02 February 2022

OBJECTION - HORSLEY DRIVE BUSINESS PARK – STATE SIGNIFICANT DEVELOPMENT APPLCIATION 17161650

EXHIBITION OF EIS - HORSLEY DRIVE BUSINESS PARK STAGE 2 BUILDINGS 2 & 3 - CNR COWPASTURE ROAD & TRIVET STREET, WETHERILL PARK

HRV - Heavy Rigid Vehicle
Overall Length 12.500m
Overall Width 2.500m
Overall Body Height 4.300m
Min Body Ground Clearance 0.417m
Track Width 2.500m
Lock-to-lock time 6.00s
Curb to curb Turning Radius 12.500m
Design Speed 10km/hr

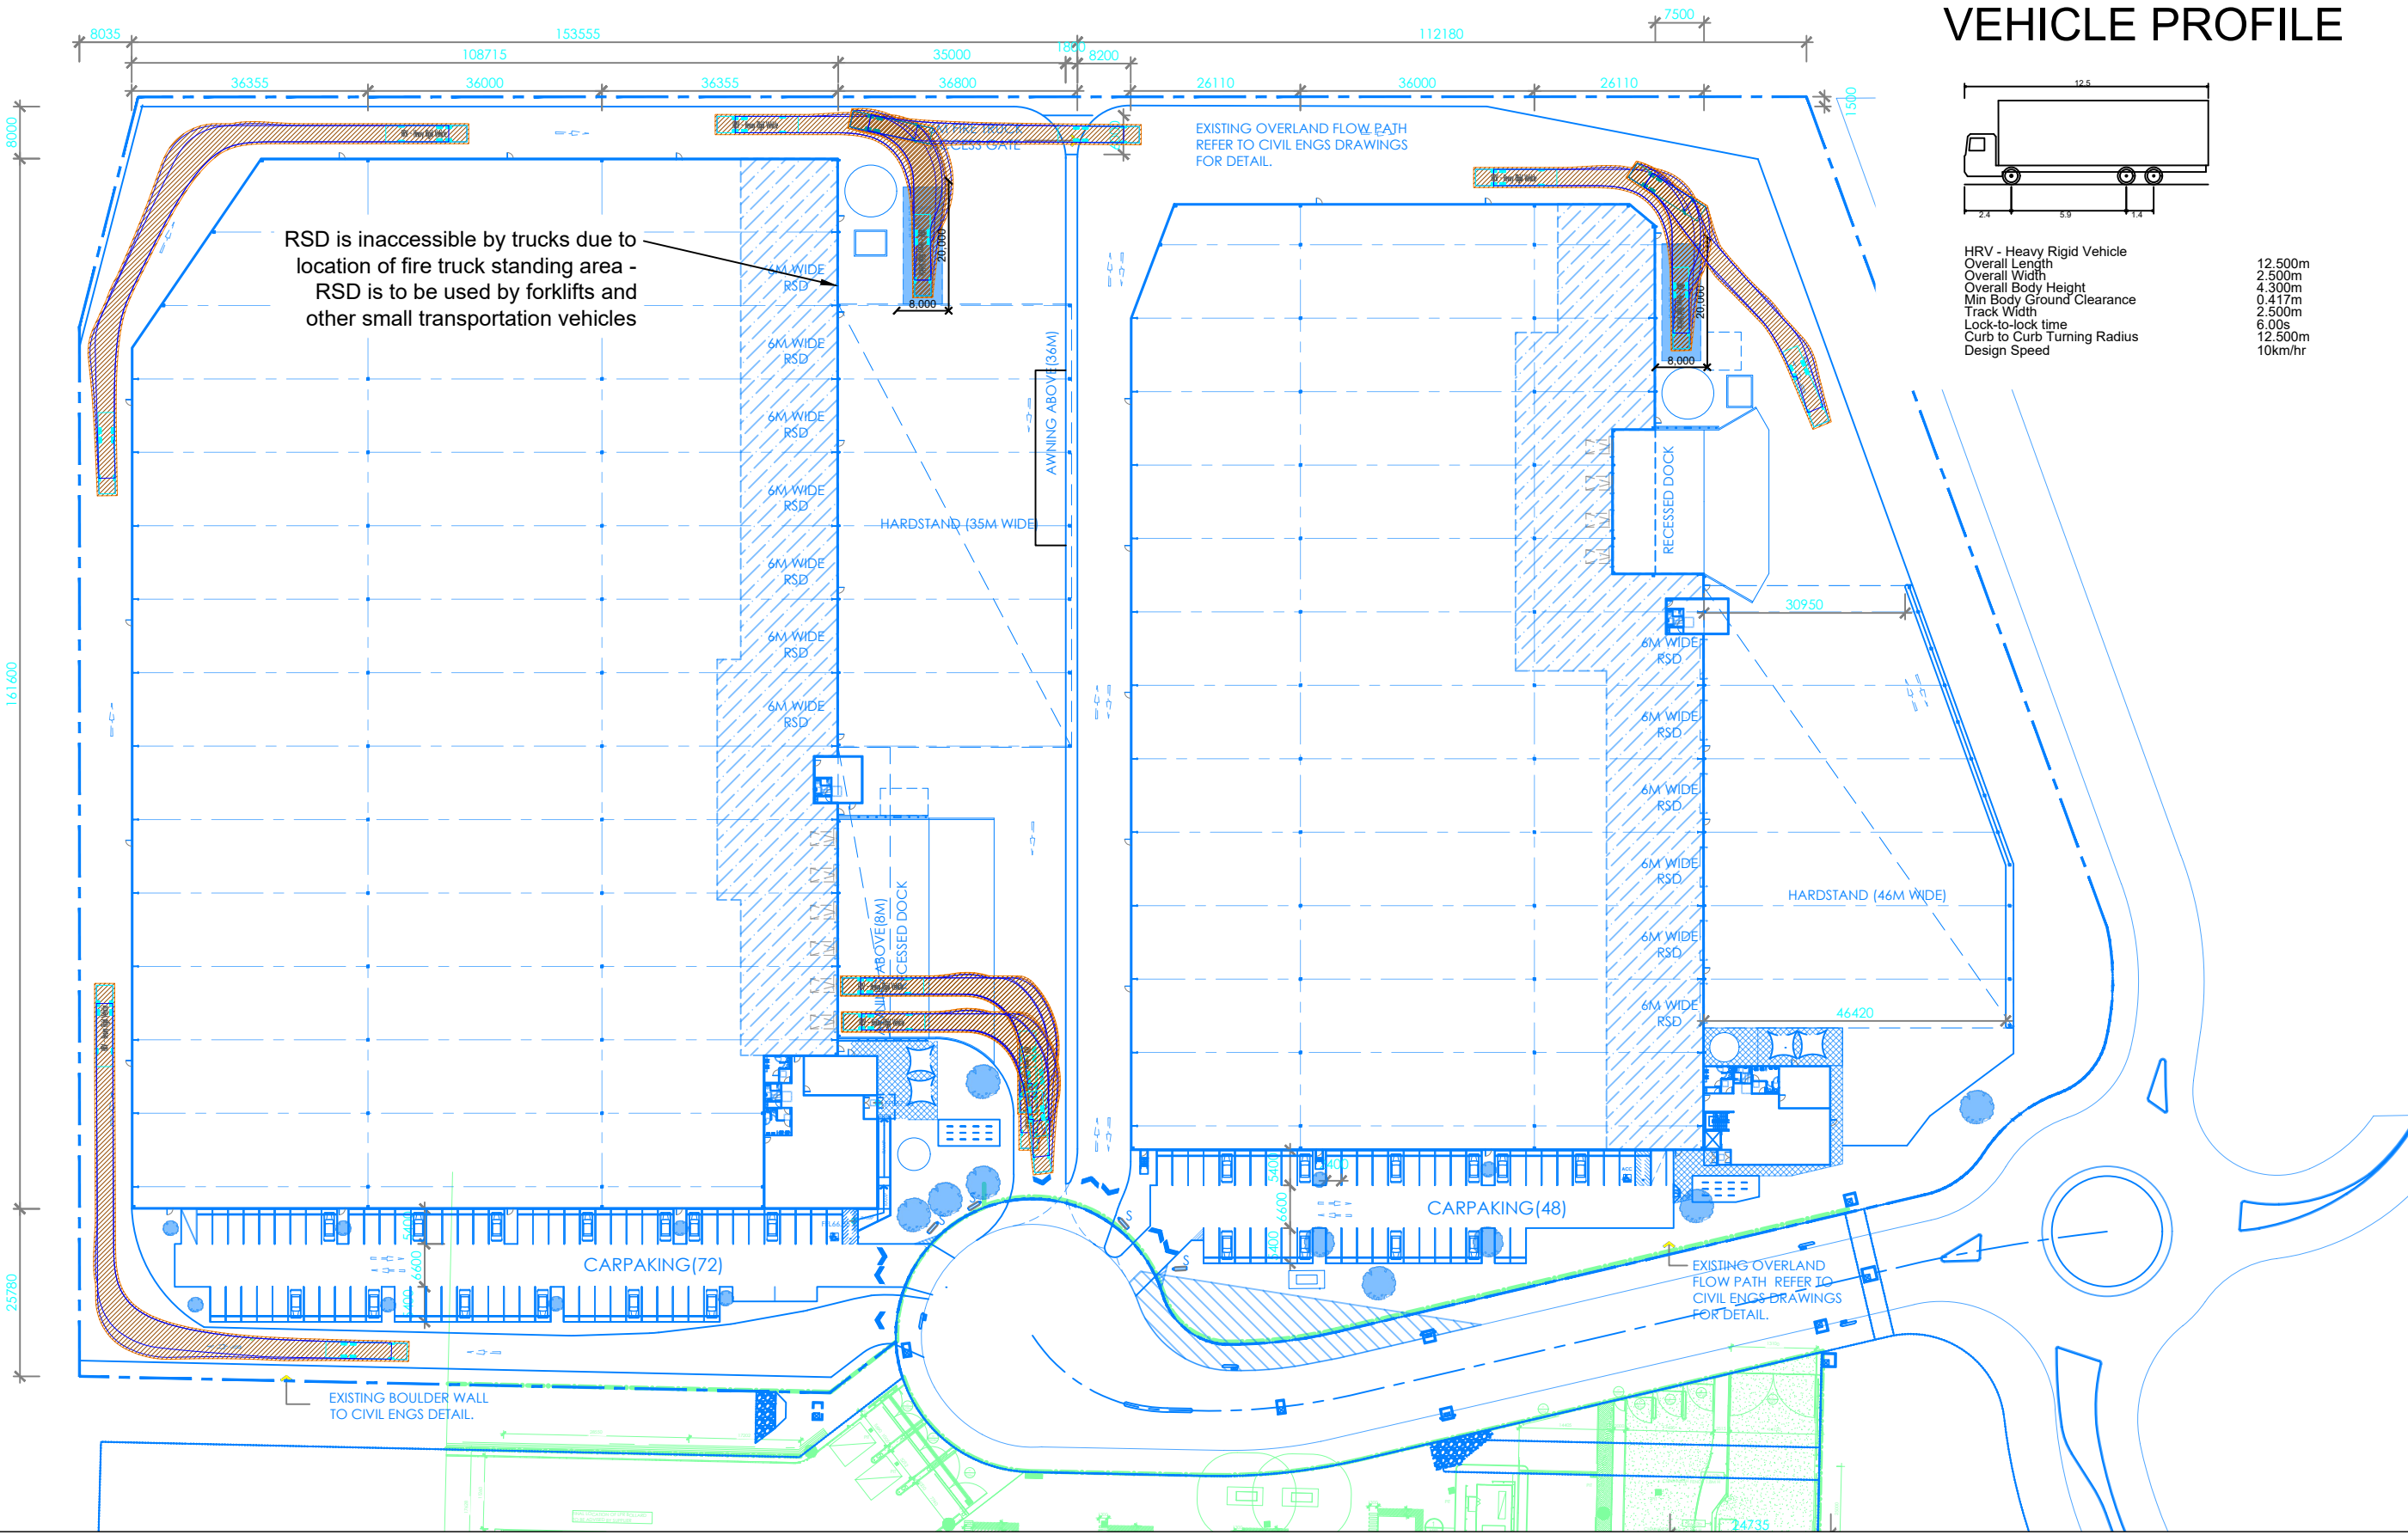
- a. The applicant's OTMP shows, Warehouse 3 is expected to generate 24 vehicle movements (with 7 heavy vehicle movements i.e. 3-4 trucks are anticipated) during the AM and PM peak hours. Based on the applicants' swept path diagrams, the site in its current form would not have the capacity to support the simultaneous movements of 26m B-Double trucks and another vehicle at/near the driveway areas and at the intersections within the site. Where two-way traffic flows are not feasible, the installation of restrictions to allow one-way traffic flow shall be considered.

- c. The swept path analysis shows that it would be difficult for 25m/26m B-Double vehicles to exit the site (turning left out of the site) onto the Estate Road without crossing the Centre of the road particularly with the worst-scenario where vehicles are parking on the Estate Road at/near the site. In this respect the site layout and access arrangement are not satisfactory. Based on the swept path analysis, the development proposal would impact on the surrounding road network's traffic operations and road safety.

- a. The truck exit point for Warehouse 2 and Combined Entry / Exit for Warehouse 3 are too close and likely to create confusion to the truck drivers servicing the sites. The access points need to be separated with adequate distance to enable safe entry and exit from the sites.
- b. The B-Double trucks shown at the loading docks at Warehouse 3 appear to encroach onto the manoeuvring areas. The truck manoeuvring areas shall be clear of loading unloading areas.
